Your Ref: OWPC19636
Our Ref: AL/74/18/PL
Please ask for:
Mr S Davis

Insertion of 1 No. dormer window to front elevation of Plot 1 & alterations to front door surrounds following the grant of AL/5/18/RES.

Woodgate Farm Westergate Street Westergate

1 : 50

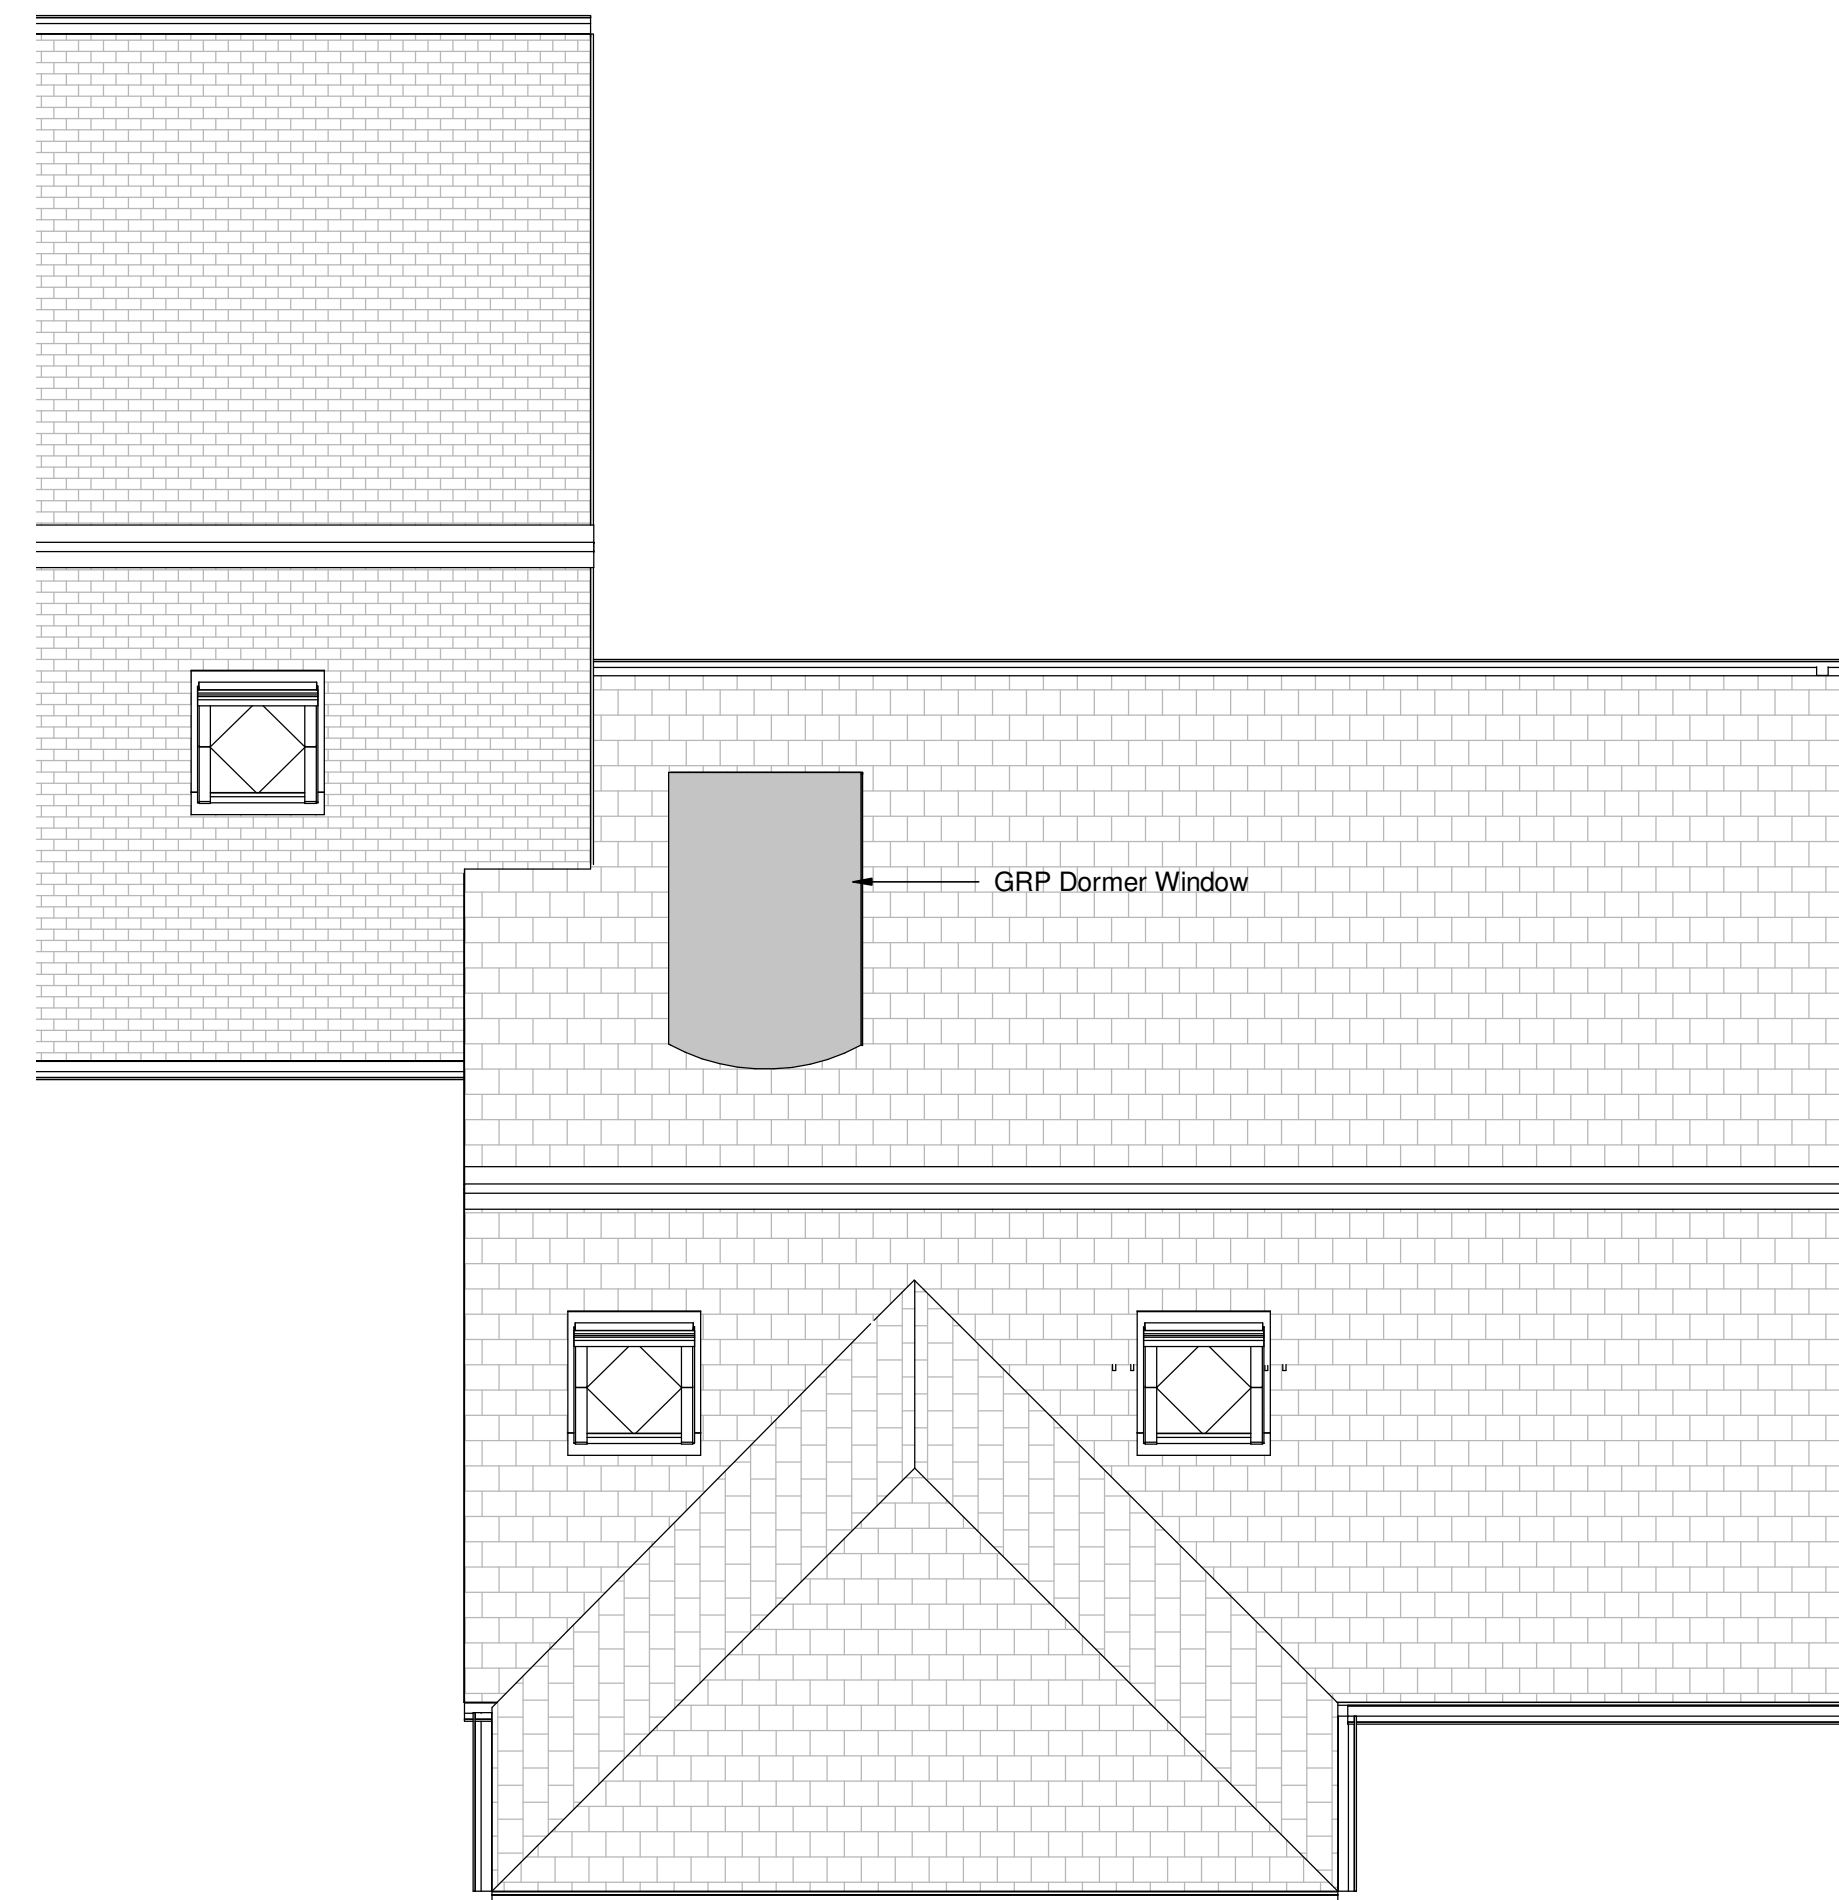
Contrary to policy H1 of the APC NP, the proposed dormer is not in keeping with surrounding properties.
